STATE OF WASHINGTON
DEPARTMENT OF ECOLOGY
1250 W Alder St • Union Gap, WA 98903-0009 • (509) 575-2490

August 15, 2017

RE: Ecology SEPA 6503 Comments for The Commons at Dry Creek preliminary plat

MDJ CONTRACTORS
CURRIER HEIGHTS PUD
PRELIMINARY SITE PLAN

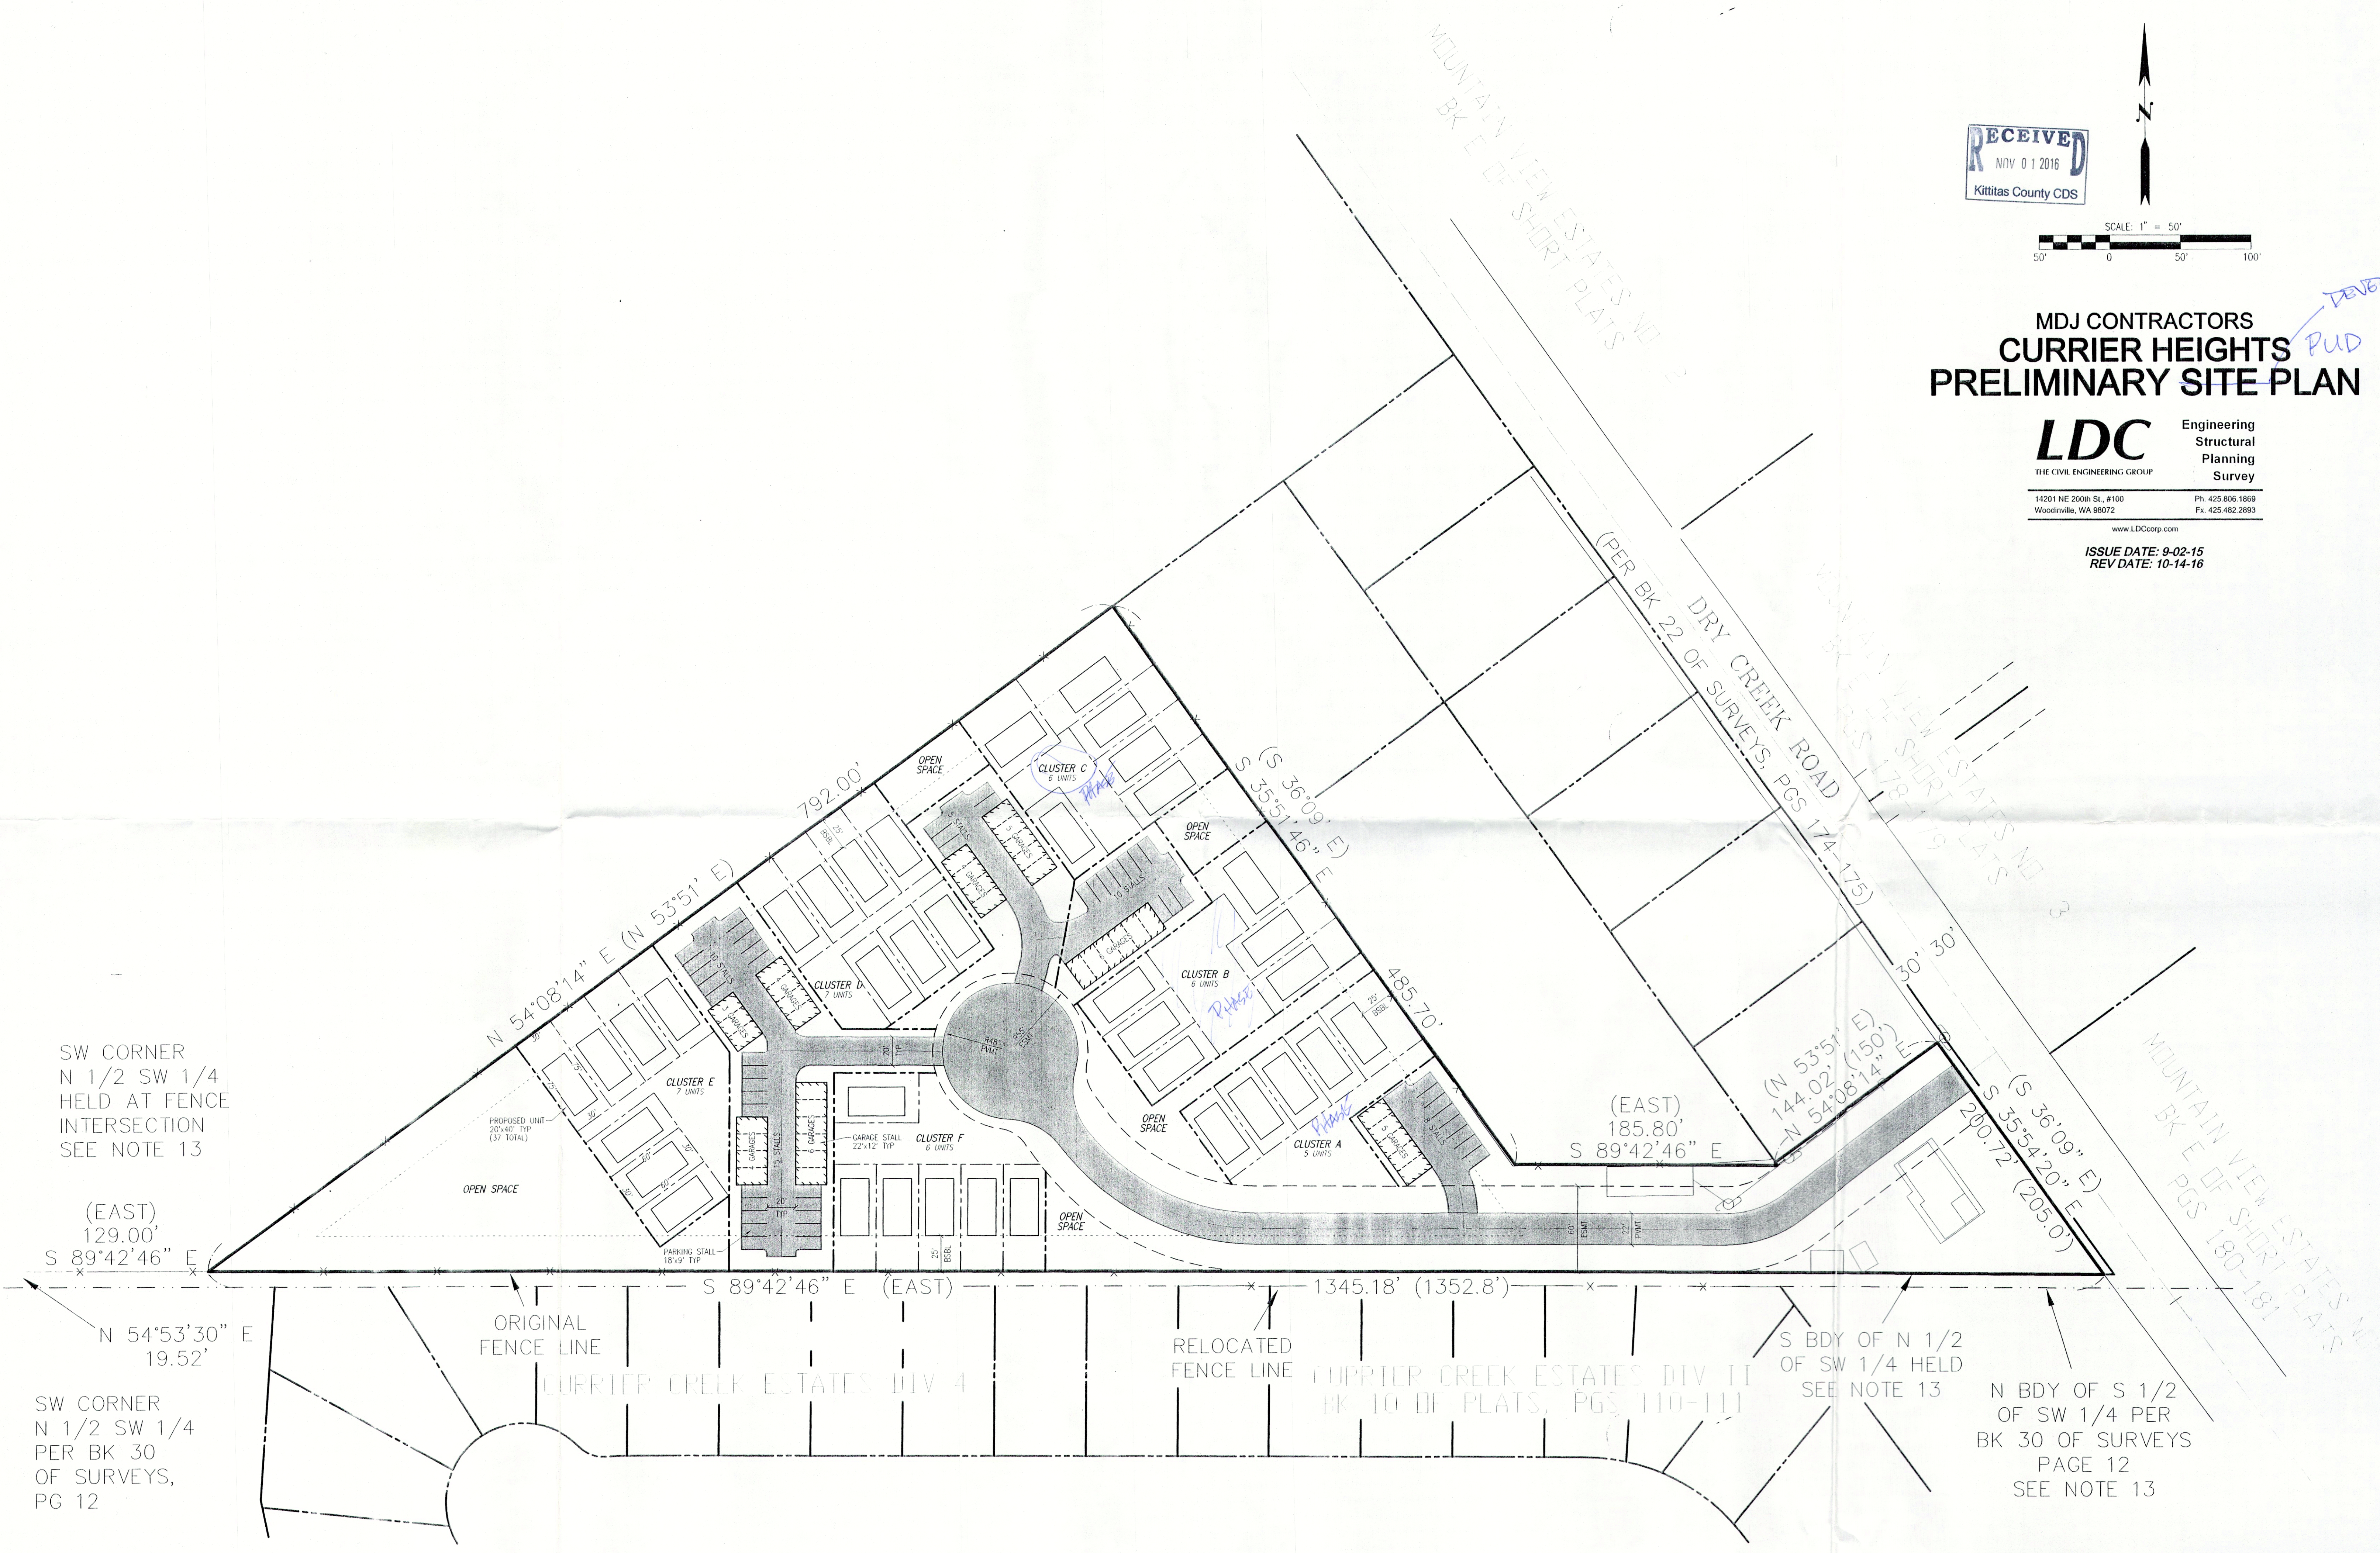
Dry Creek is in close proximity to the Jackson property; therefore, the ordinary high water mark, stream classification and regulated buffer setback need to be identified. Any regulated buffer overlap on The Commons at Dry Creek should be identified and shown on plan sheets.
